ADDISON ESTATE

ADDISON ESTATE, 702 FIELD END ROAD, LONDON, HA4 0QP

OUTLINE FIRE SAFETY STRATEGY

FIRE SAFETY STRATEGY					
ISSUE	DATE	AUTHOR	REVIEW	VALIDATED	General comments/ Amendments
A	22/06/23	OW	JL	JL	Issued for design team review and comment

103 PROPOSED FIRST FLOOR PLAN
 Scale: 1:100

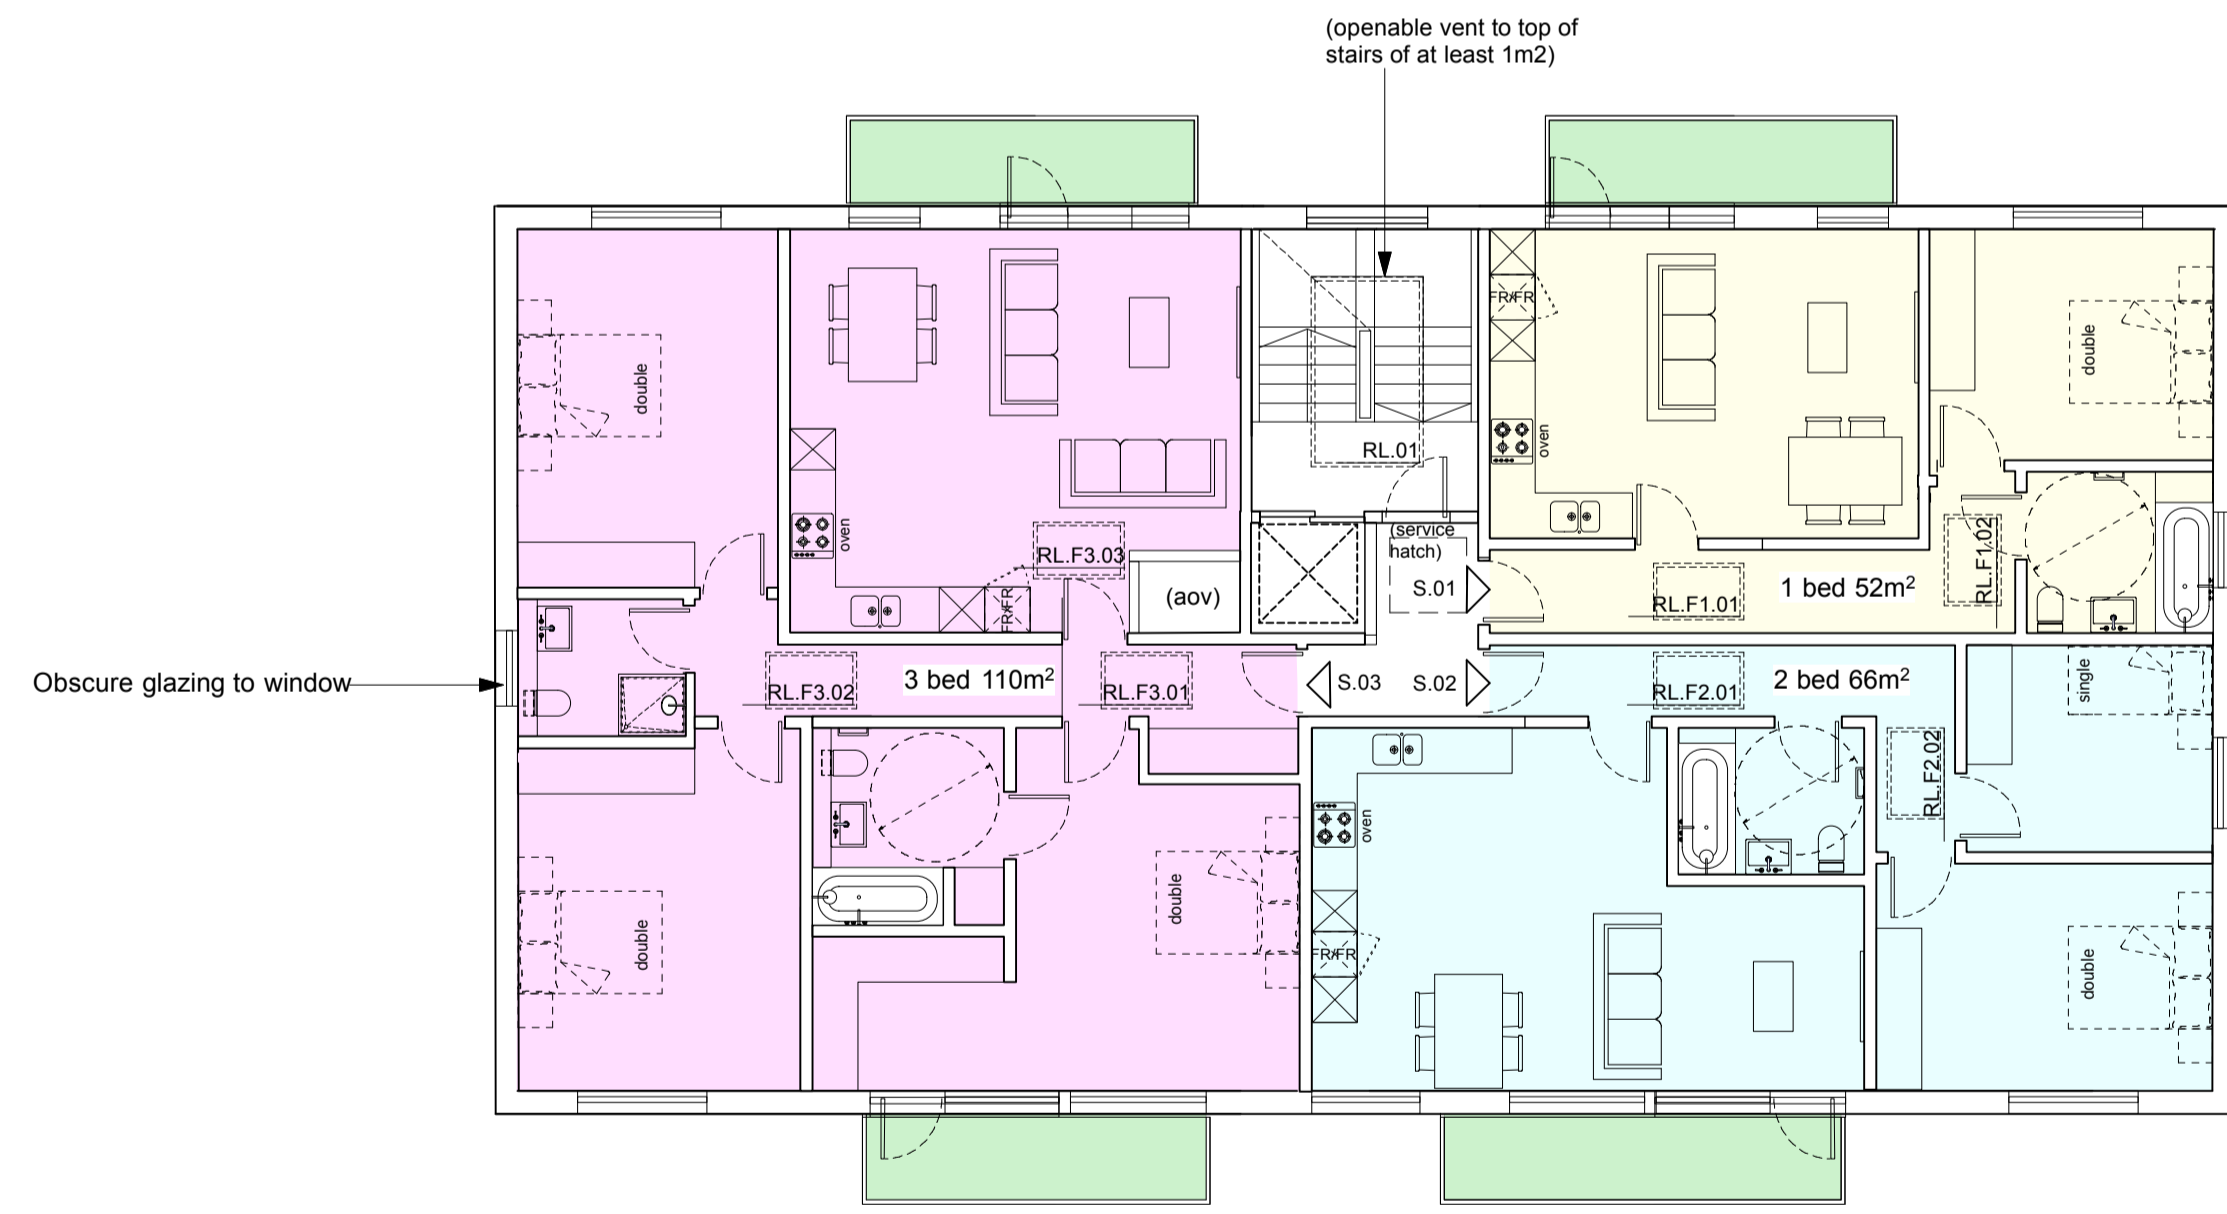
The common area escape in Addison Estate is via internal corridors that link to the escape stair. Per Figure 8, the maximum travel distance from the flat entrance door to the stair should not exceed 4.5m.

Figure 2 - Extended travel distances from first floor level

As shown by Figure 2, there are extended travel distances from the first-floor level and as such the client should consider the following options to comply with the prescriptive guidance recommendations

- Provide 1.5m² AOV to the residential common corridors on all floor levels or;
- As shown by the blue circle in the red cloud, move the flat entrance door to this location so that it is within the 4.5m to the stair as per the prescriptive guidance recommendations.
